Appeal Decision

Appeal Ref: APP/R5510/W/22/3309744

251 Long Lane, Hillingdon, Uxbridge UB10 9JP

- The appeal is made under section 78 of the Town and Country Planning Act 1990 against a refusal to grant planning permission.
 - The appeal is made by Arif Sheikh against the decision of London Borough of Hillingdon.
 - The application Ref 76753/APP/2021/3469, dated 13 September 2021, was refused by notice dated 29 April 2022.
 - The development proposed is Subdivision of plot and erection of 1 x 2 bed dwelling (Use Class C3), landscaping, and associated works.
-

1:200
Proposed Street Elevation

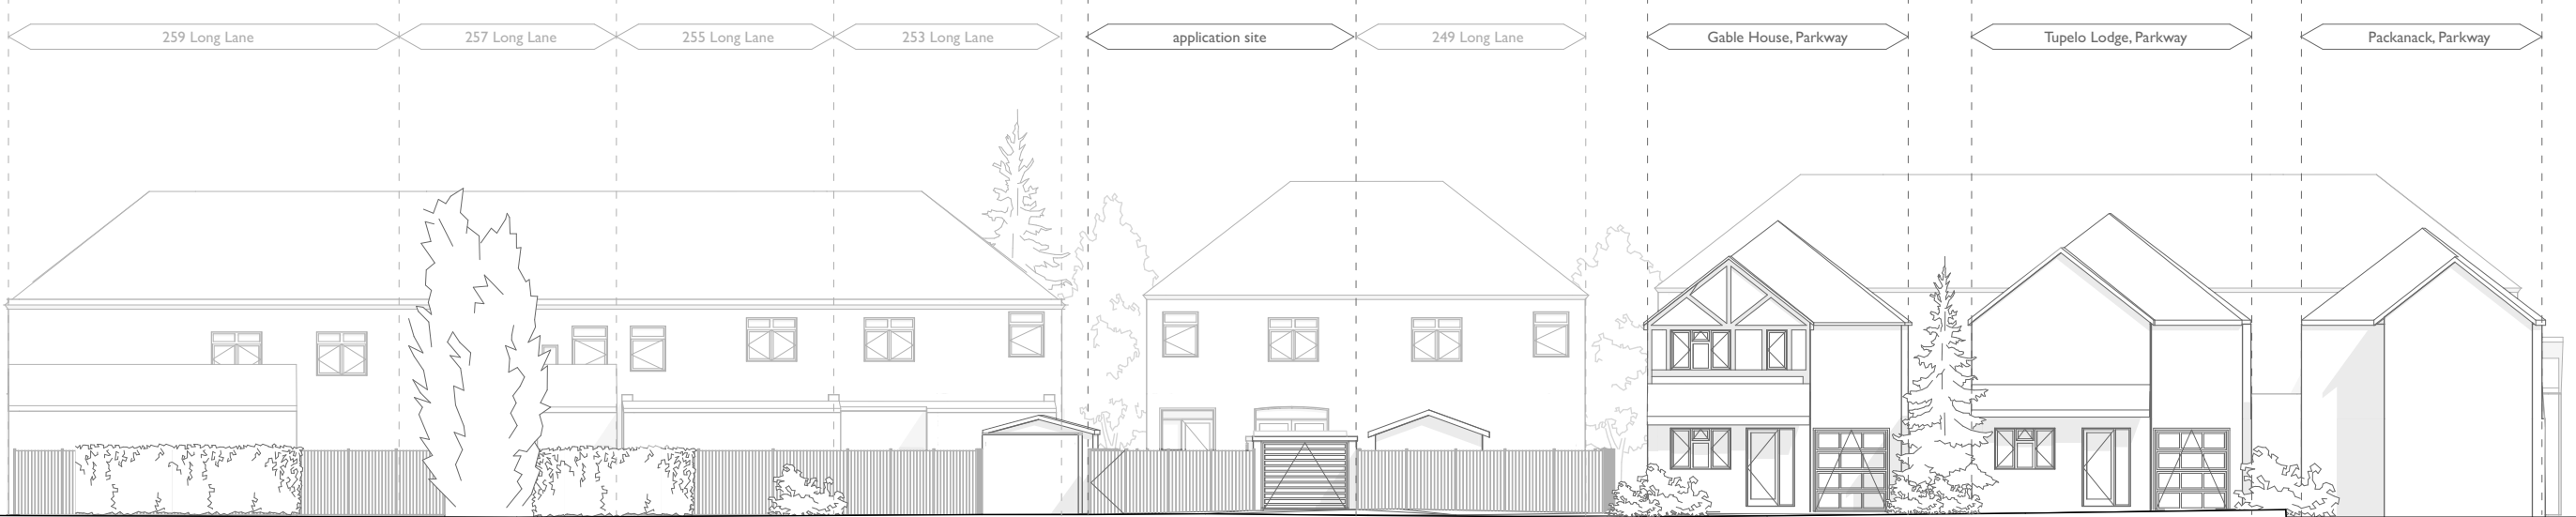
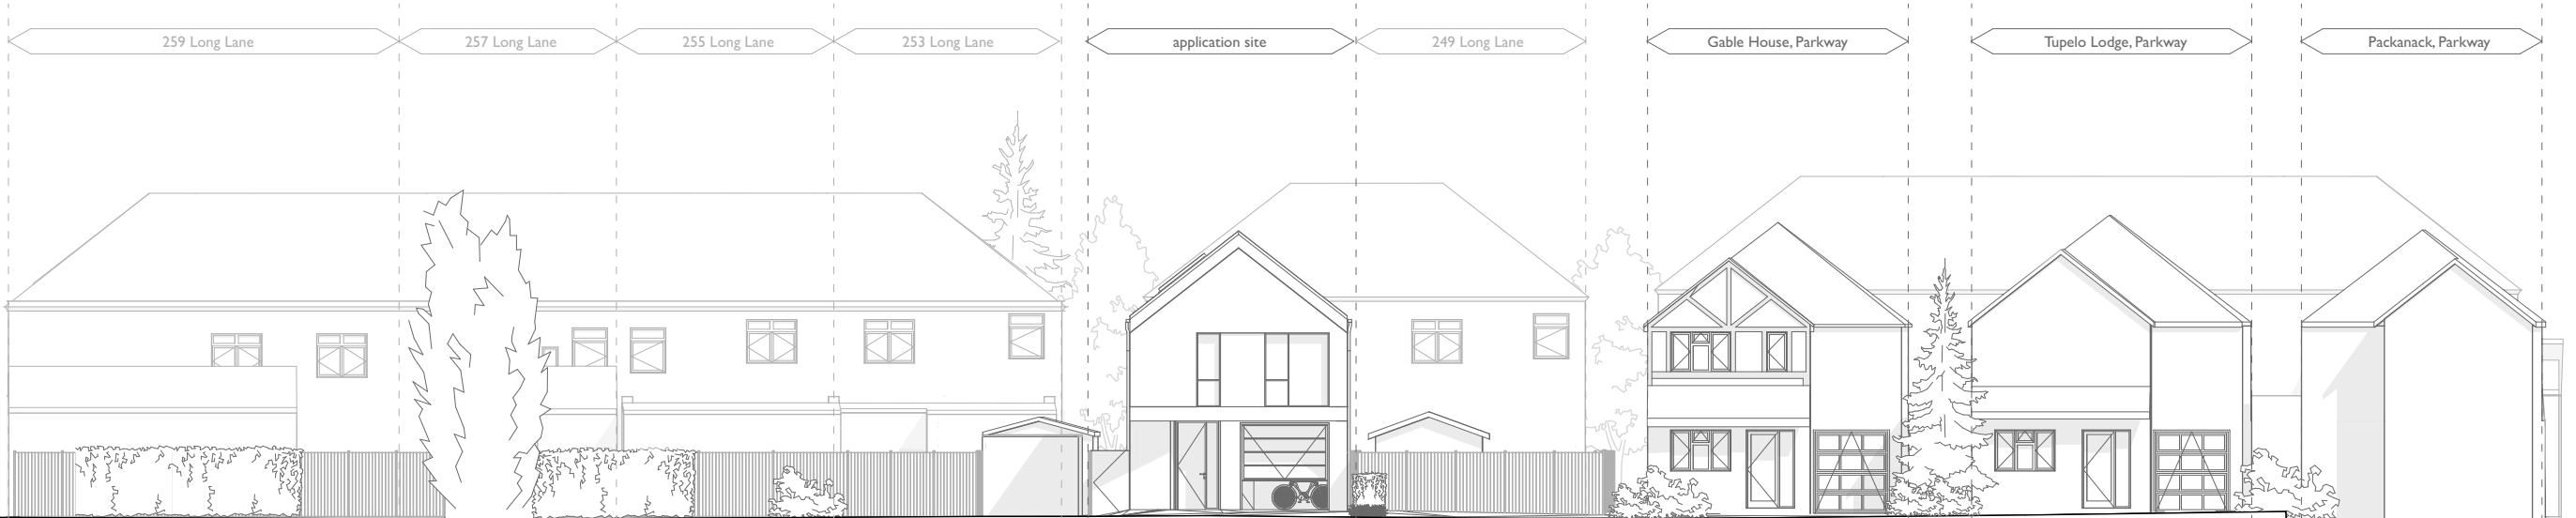
5. The proposal would most closely relate to the modern houses that have been built within rear gardens adjacent to the appeal site. This proposal would however differ from these as the plot size is visibly smaller. The proposed scale and massing would fill most of the width of the plot with built development and only a small pedestrian gap to one side of the house remaining. In addition, despite the proposed overhang, its set back from the front of the site would be very limited, further amplifying its bulk.

6. The proposed dwelling would appear cramped in its plot and out of character with the street scene where the layout of other plots are visually more spacious when compared to the appeal site, and the dwellings appear proportionately in scale to the size of the plot. This is taken together with greater private space surrounding others. This proposal would lead to detrimental visual intrusion to the character and appearance of the street scene.
